Our Ref: SSD 7256 MOD 3

**Response to Submissions
ResourceCo Resource Recovery Facility Modification (SSD 7256 MOD 3)**

SUBJECT: MODIFICATION APPLICATION FOR RESOURCE RECOVERY
FACILITY AT 35-37 FRANK STREET, WETHERILL PARK

**SSD 7256 – Cleanaway ResourceCo Wetherill Park – Modification Application (Mod 3) –
Amendment of Approved Site Layout Plan to Increase the Designated Area for Bale Storage**

SITE PLAN-PART 1
1 : 250@A1
1 : 500@A3

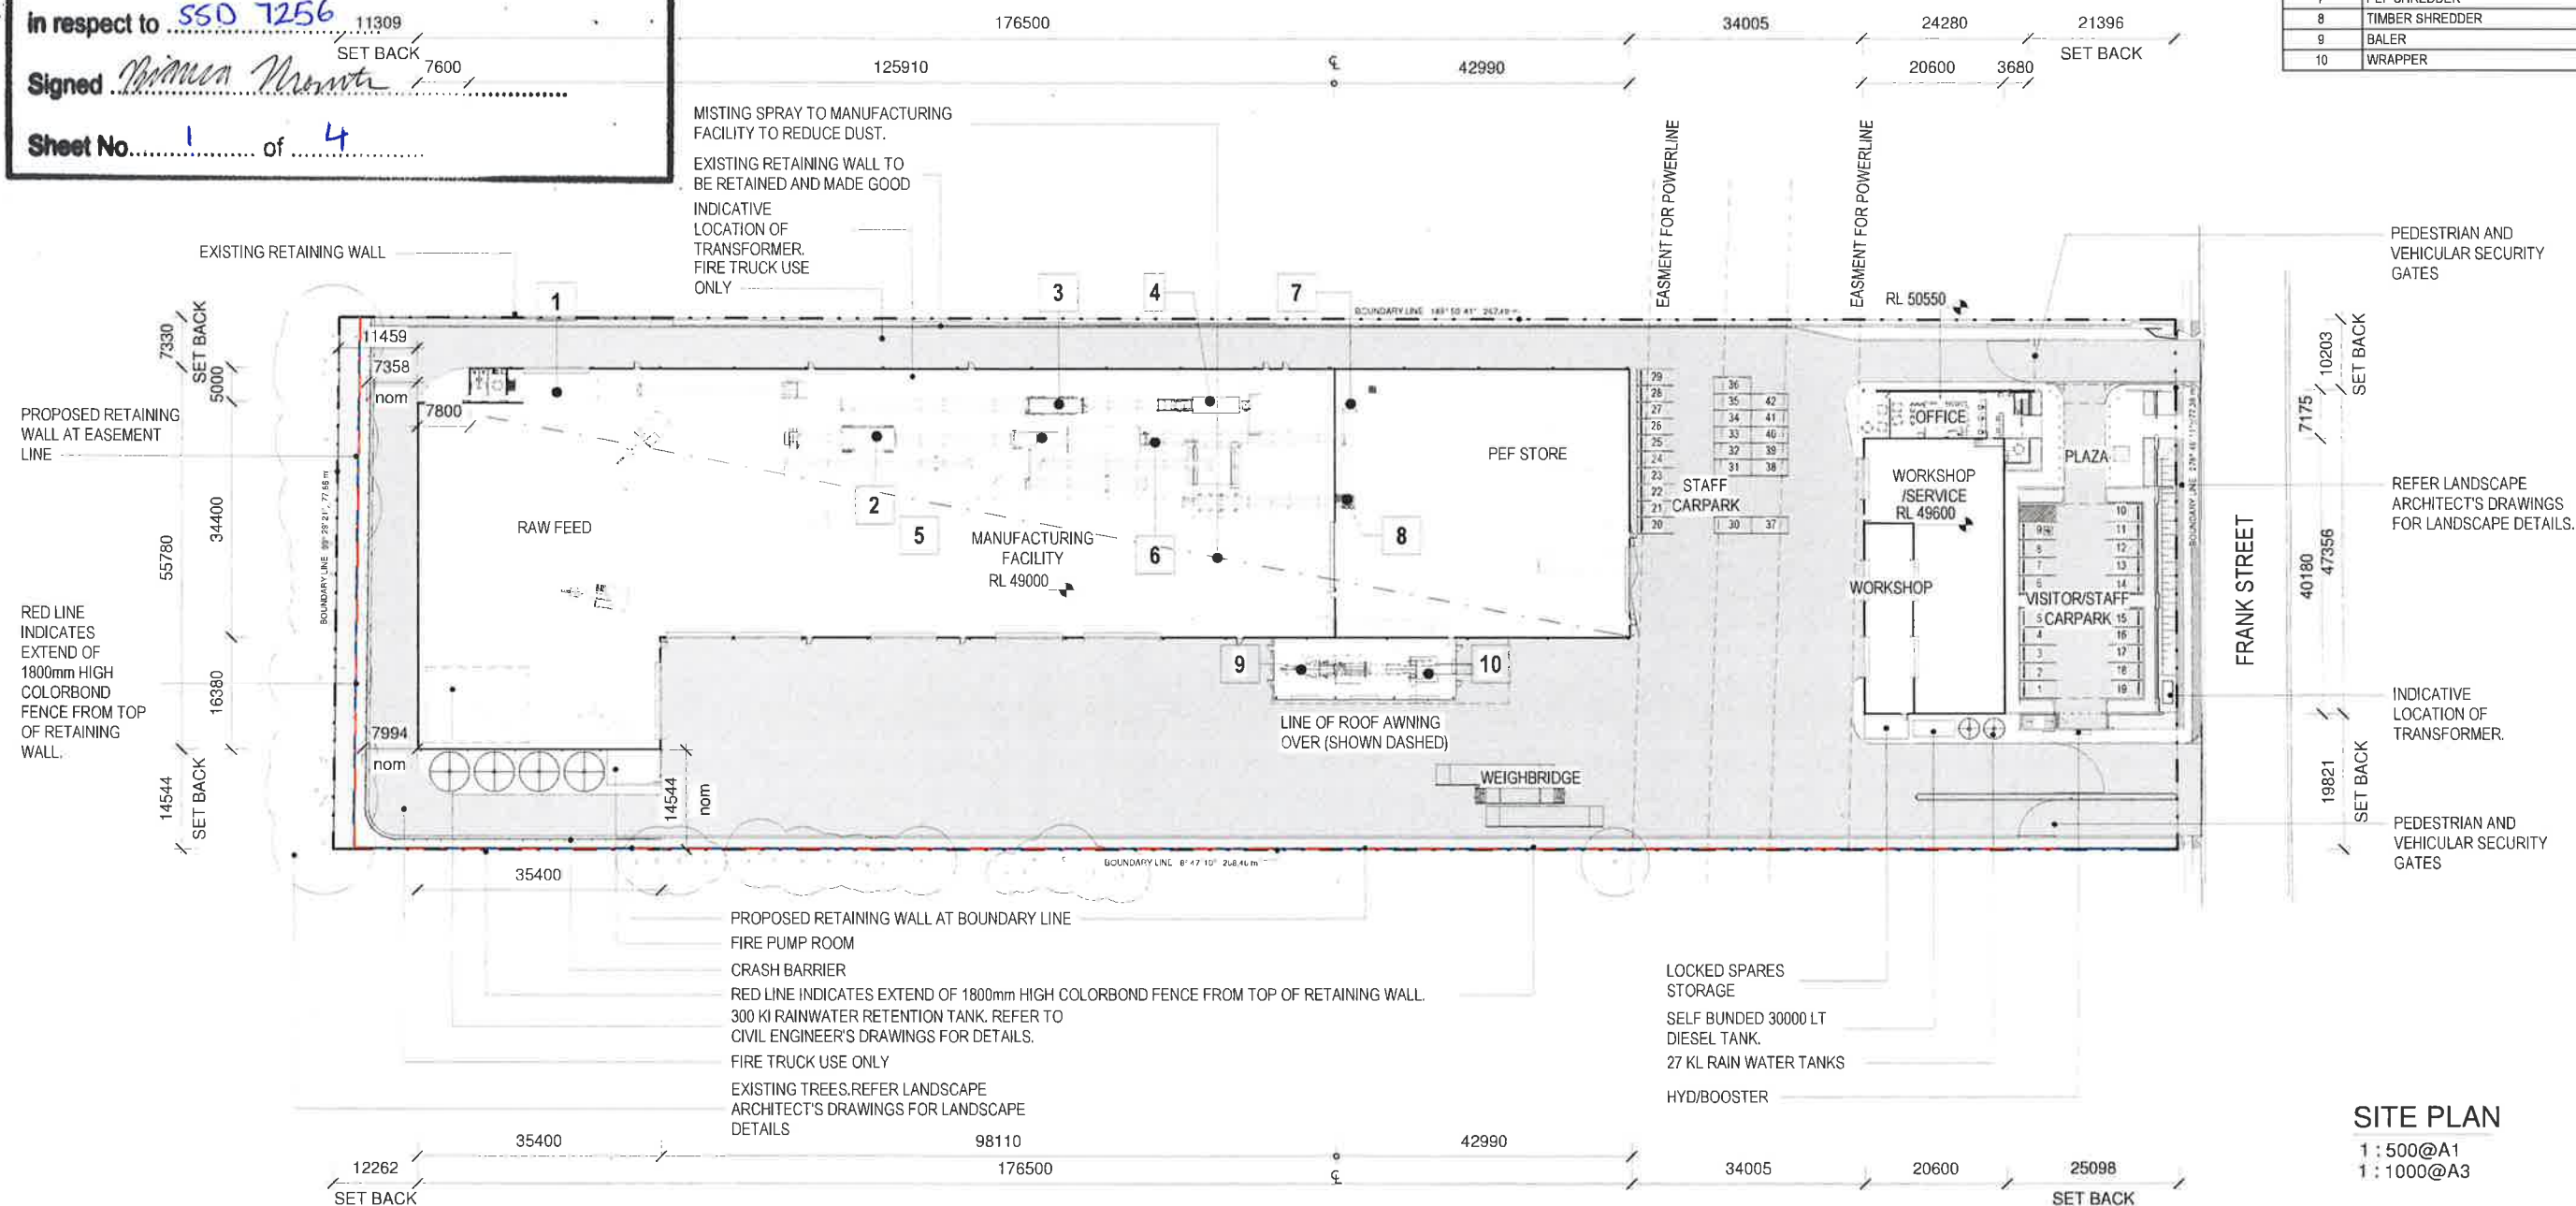
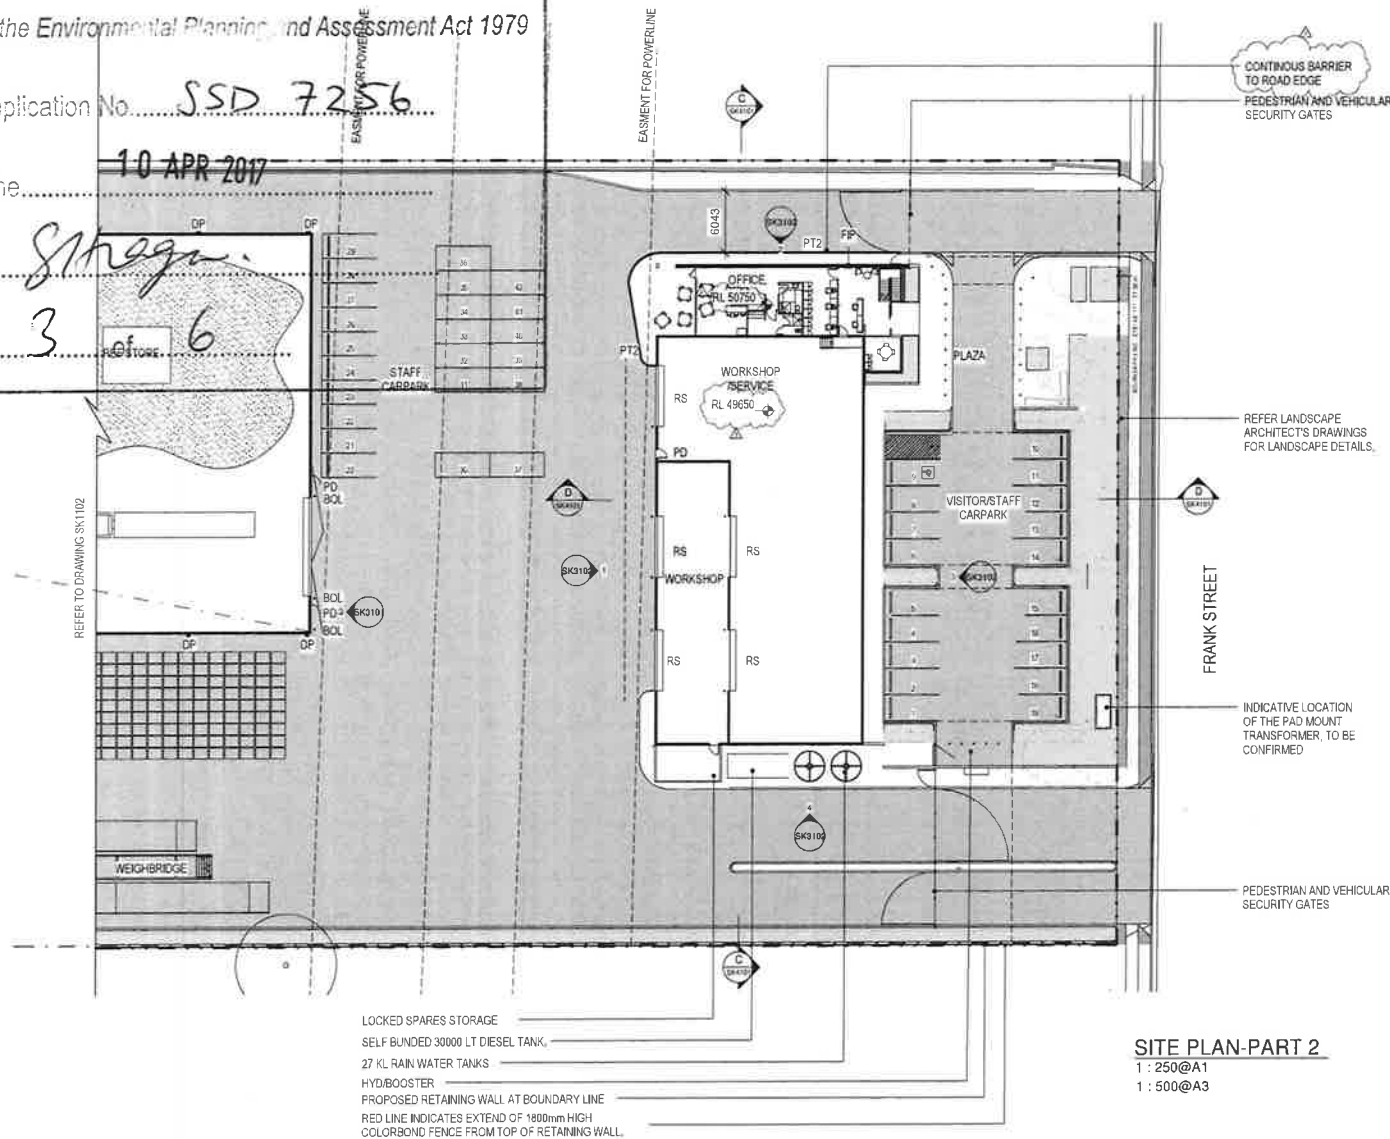
A review of the plans reveal that the storage area at the site shall be differentiated from the manoeuvring/circulation areas by signposting and line markings.

Swept path diagrams provided by the applicant show the manoeuvring of 19m long articulated vehicles and 26m long B-Double vehicles within the site. However, the movements of the articulated and B-Double vehicles manoeuvring into and out of the driveway onto 35-37 Frank Street, Wetherill Park are not shown on the swept path diagrams.

into the site due to the proposed access arrangement. The swept path diagrams provided by the applicant need to show 19m long and 26m long vehicles can satisfactorily manoeuvre into and out of the driveway and which direction these vehicles are travelling to/from Frank Street.

The applicant shall also clarify whether the access driveway located on the south-eastern corner of the site will be used by vehicles and/or trucks.

5. Details on how the safe and efficient movement of pedestrians and vehicles will be achieved throughout the operation of the development is requested. While updated swept path diagrams have been provided, there are two areas of concern regarding truck manoeuvrability:
 - the area between Bale Storage B and the weighbridge
 - the area between Bale Storage C and Bale Storage D.The two areas of concern are shown in Figure 1.
